## Letter of Intent

Sunflower Land Care INC.

PLOT PLAN / PLANTING PLAN

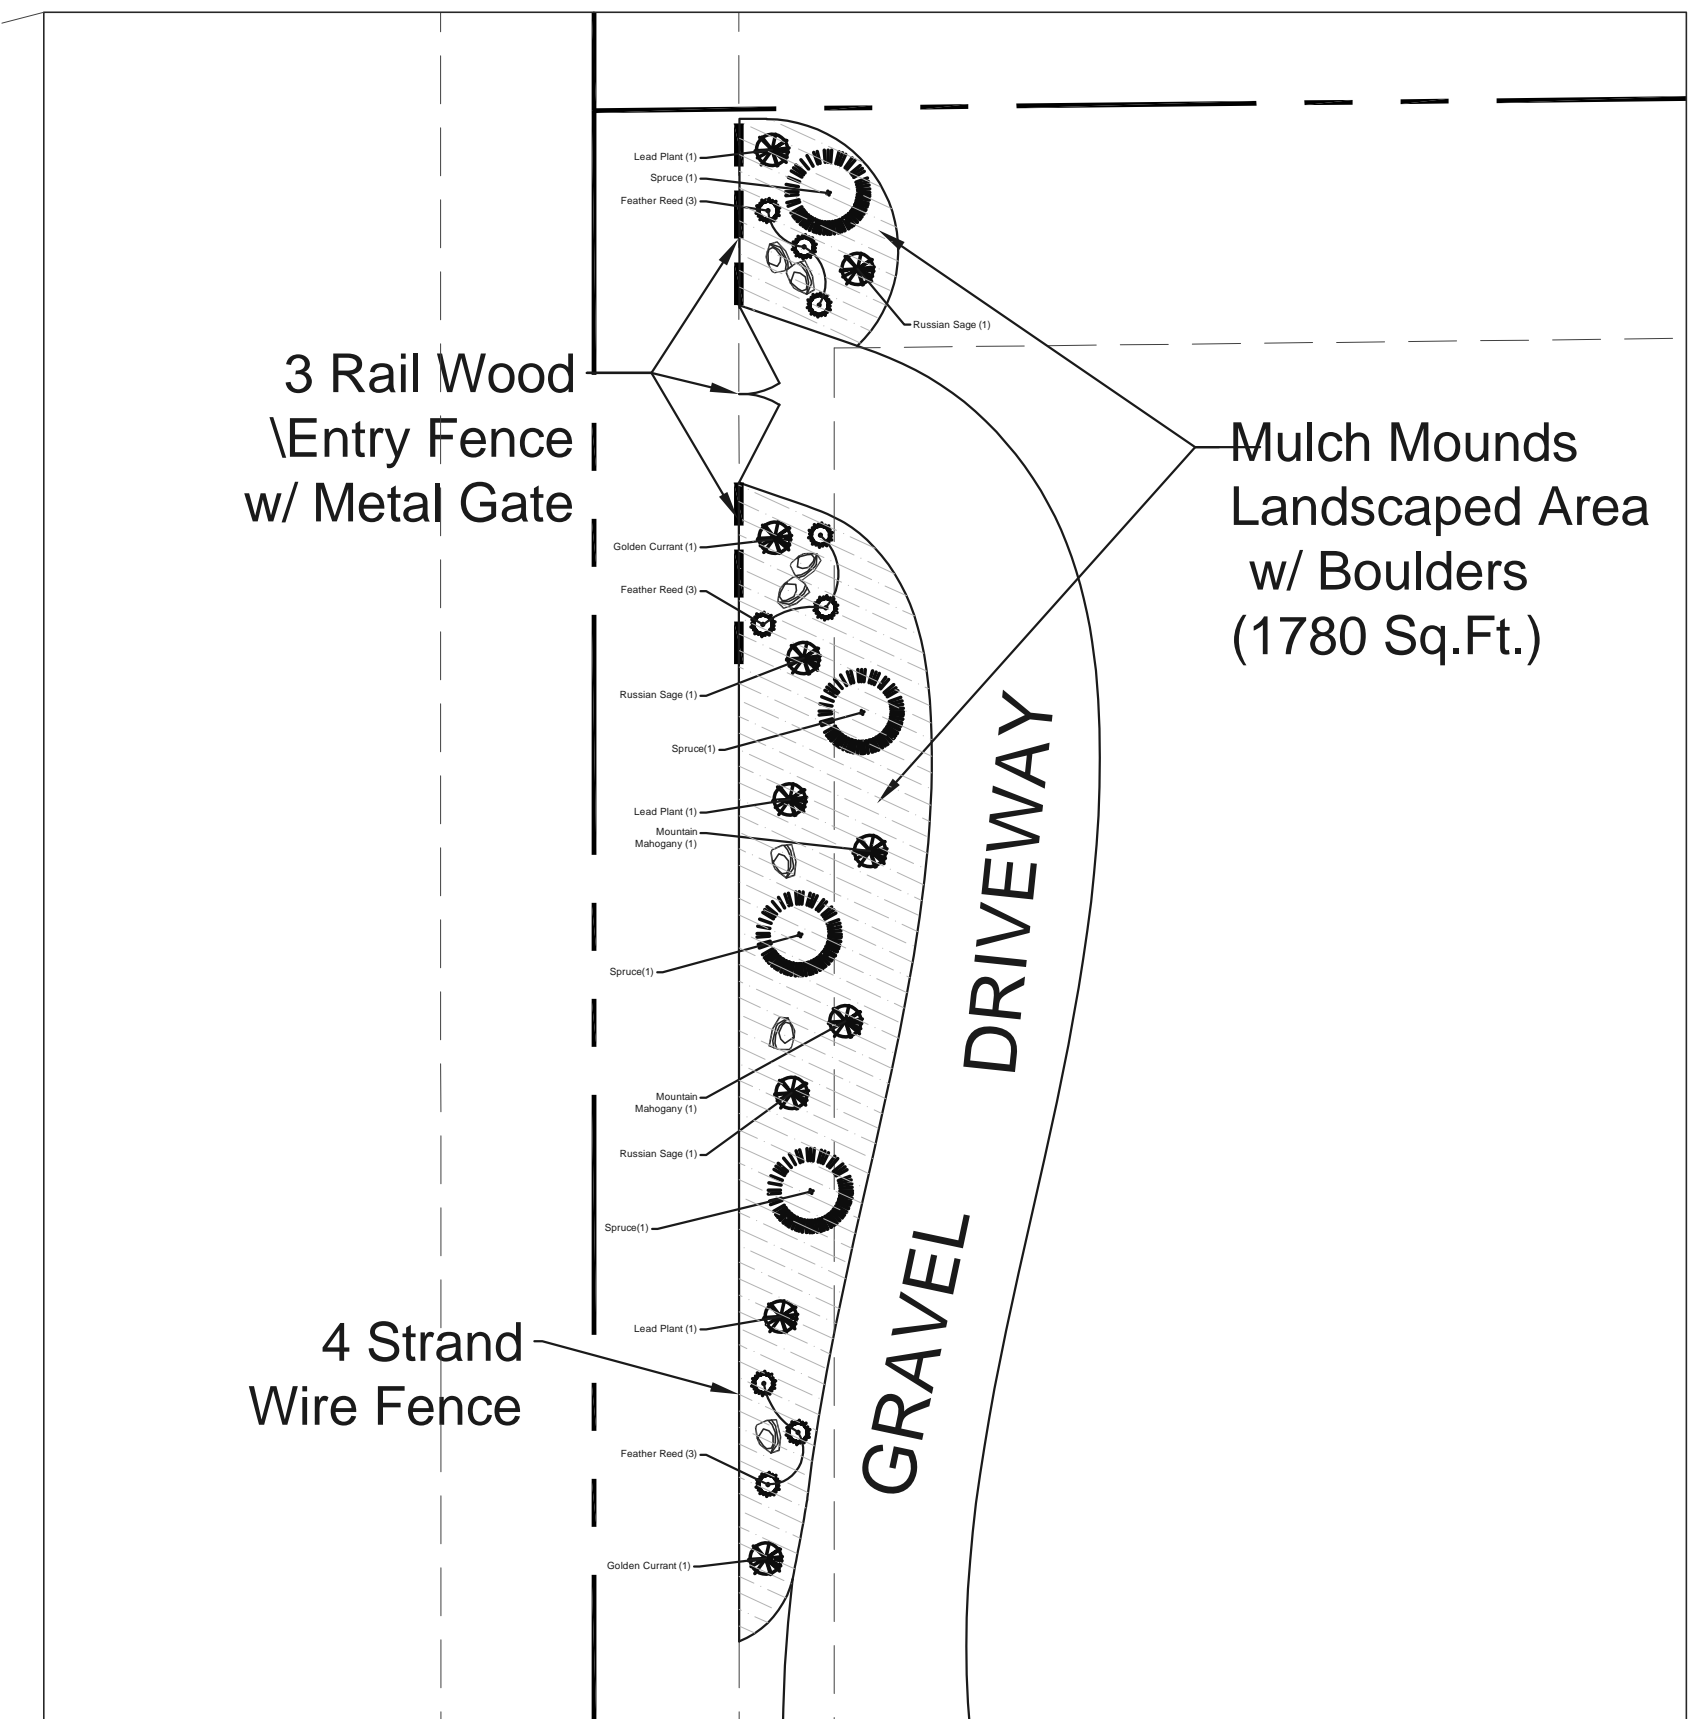
Add a section on the landscaping. If you cannot meet all the criteria in chapter 6 of the land development code you will put in this letter that you are requesting an alternative landscape plan.
